**Consultation Response from KC,
Lead Local Flood Authority**

2021/92983 Among Balay, 24, Gynn Lane, Honley, Holmfirth, HD9 6LF

Erection of single storey rear extension and external alterations

**Date Responded: 22nd
August 2021**

DRAWING TITLE: GA as Proposed

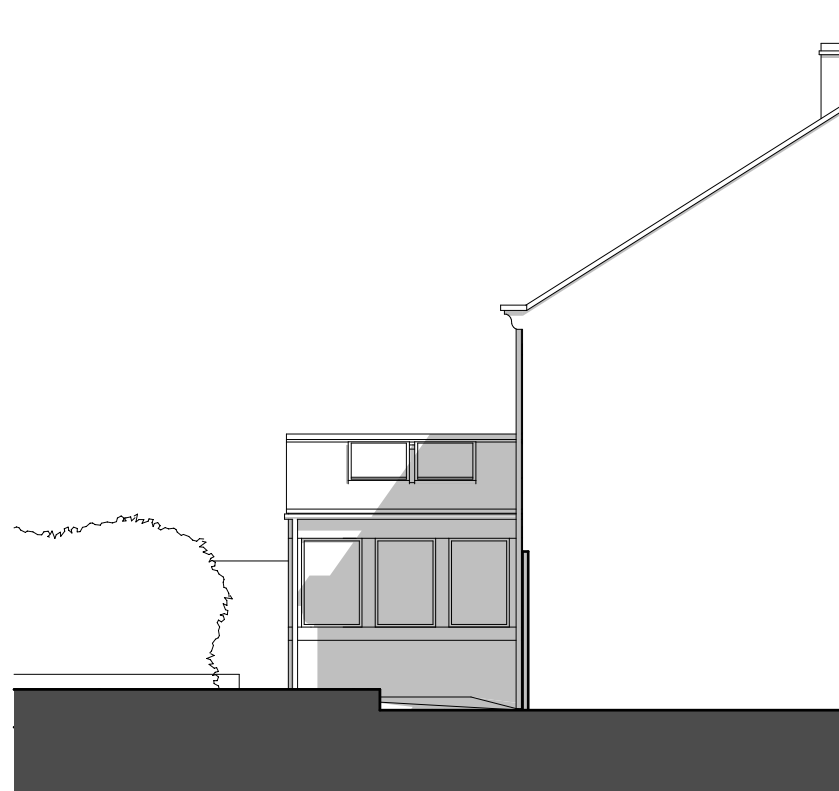
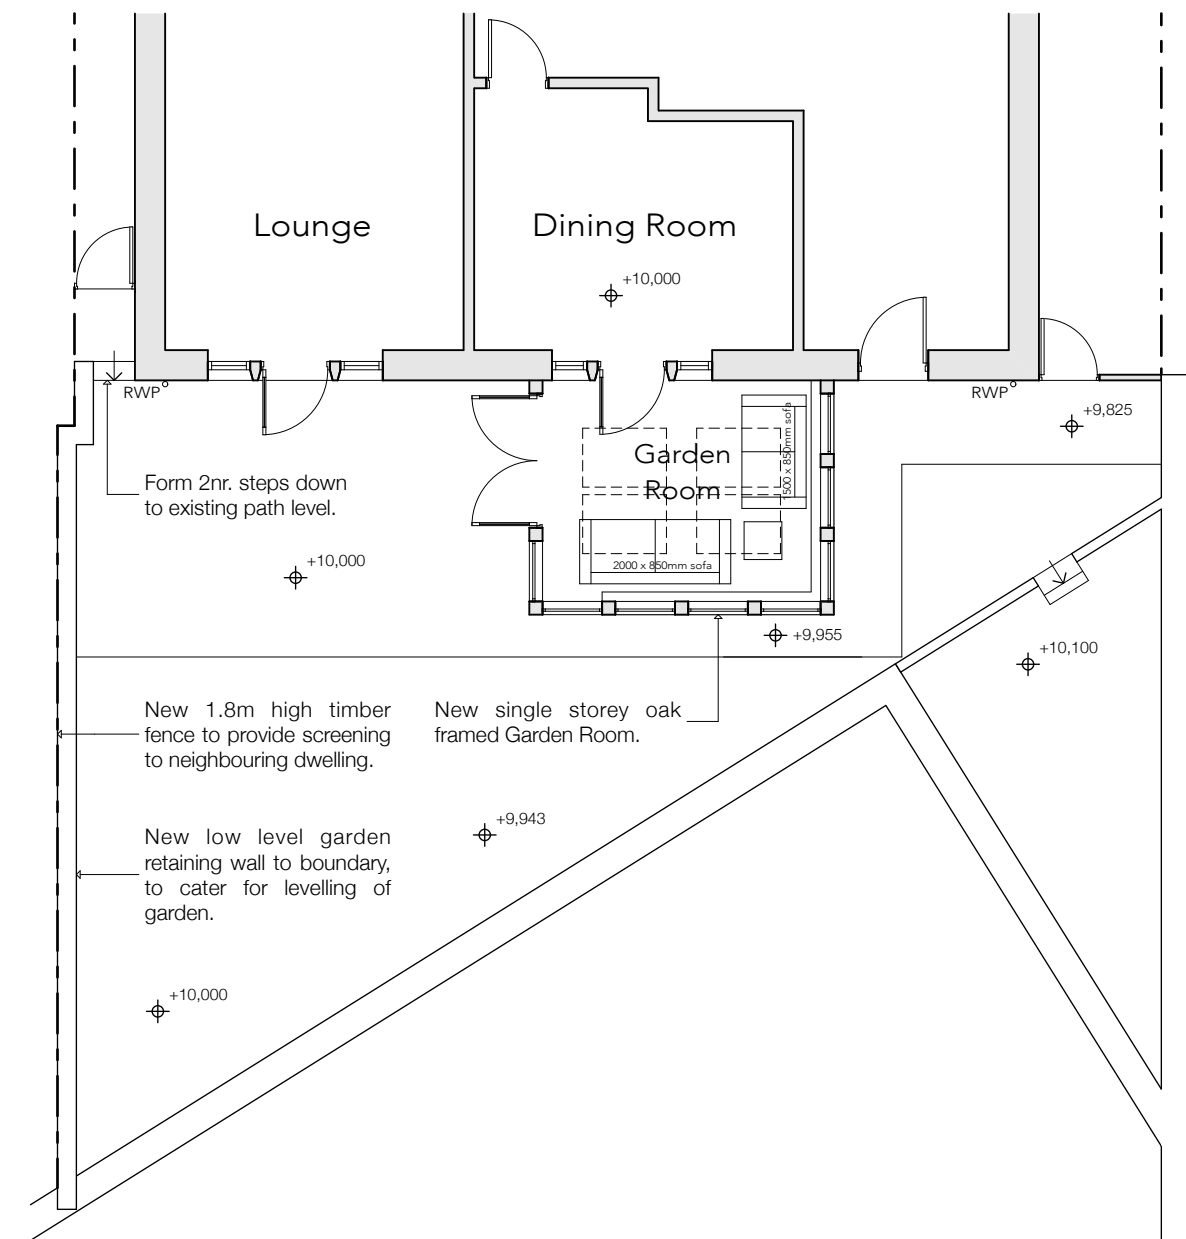
Kirklees Flood Management & Drainage OBJECT to this application due to the proximity to a enclosed watercourse.

Ludhill Dyke travels underground across this small estate including the curtilage in question. It consists in part of culvert and large pipe (1200mm). As such safe maintenance access is required and at this size and any significant depth, a stand-off of at least 4-5 metres will be requested (depth and size dependent). The extension is likely to bring the building within this safe operational limit.
